**Consultation Response from KC,
Lead Local Flood Authority**
2023/92033 Hoyle Ing Dyeworks Former, Hoyle Ing, Linthwaite, Huddersfield, HD7 5QS
Erection of 6 bungalows with ancillary staff area (within a Conservation Area)
Date Responded: 29/08/2023.
Responding Officer: Martin Stephenson
Responding Ref: 1
Documents reviewed by the LLFA:

- Drawing Ref: HA-MRLWPH2-P004, Drainage Strategy, Rev – dated 27/06/23.
- Drawing Ref: HA-MRLWPH2-P002, Drainage Strategy, Rev A dated 26/07/23.

DATE: 27-06-23 | SCALE @ A3 1:500 | DRWG: HA-MRLWPH2-P004 REV:--

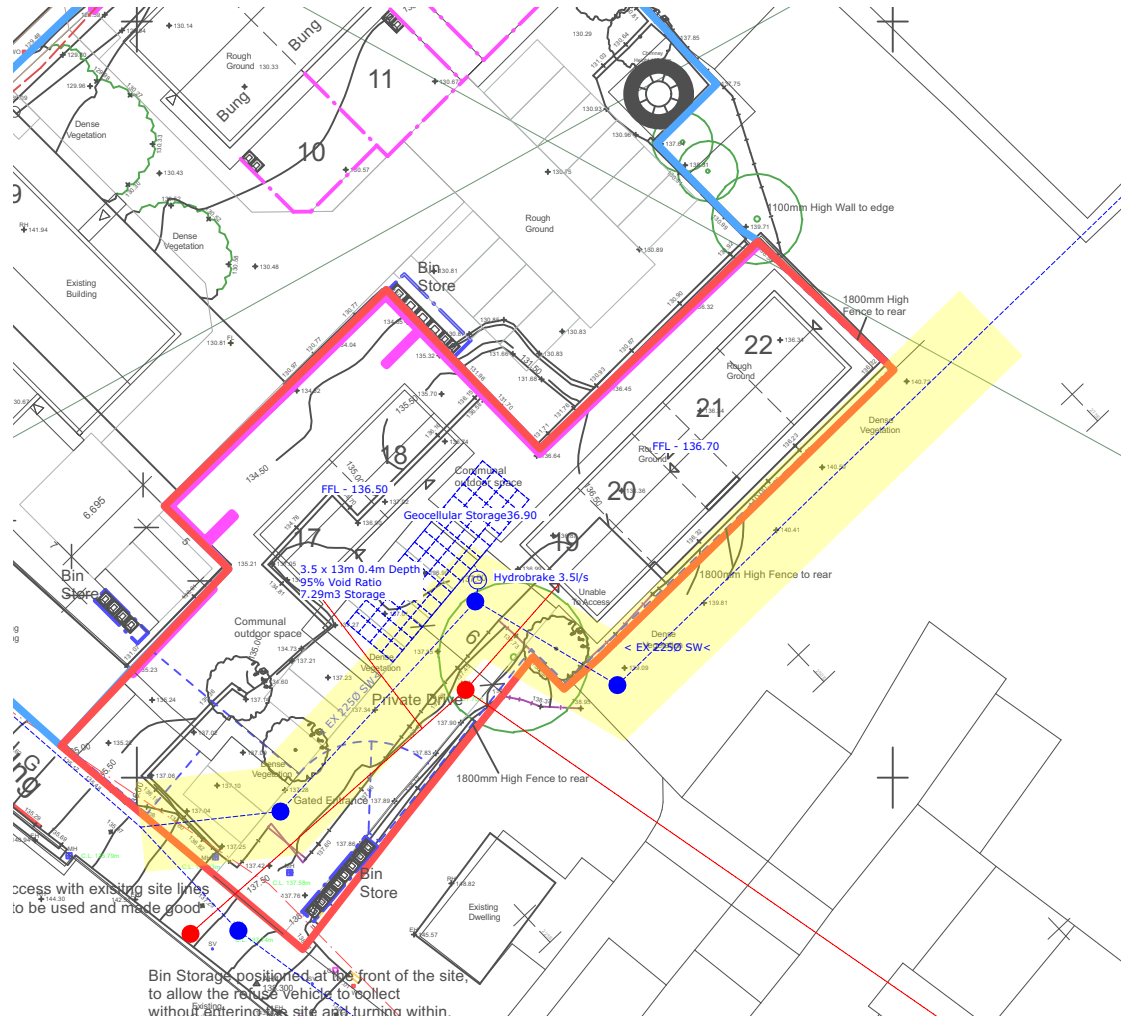
The LLFA confirms acceptance of the proposed allowable surface water discharge rate of **3.5l/s** and the proposed discharge point into the existing Yorkshire Water 225mm dia surface water sewer (subject to YW acceptance).

The size of the attenuation tank should be designed to retain all surface water flows within the site and ensure no flooding of the curtilages of existing or proposed buildings for the critical **1 in 100 year** (plus **30%**) rainfall event. The design vertical loading on the geocell tank should be specified on the construction issue drawings and should be sufficient for the estimated maximum vehicle wheel loading. The sizing of the required storage volume should be confirmed using MicroDrainage (or similar) hydraulic calculations to be submitted following the detailed design stage.

At the next stage, the developer should submit the proposed **Maintenance Strategy** for the surface water drainage within the site including a **Maintenance Schedule** and confirming which organisation will be responsible for the maintenance for the life of the development or until adoption by the statutory water authority.

The developer should also submit details on how surface water run-off will be controlled during the construction period to limit the discharge of silts onto the adopted highway and restrict surface water flow rates to **2.5 l/s per ha** for the **1 in 2 year** rainfall event.
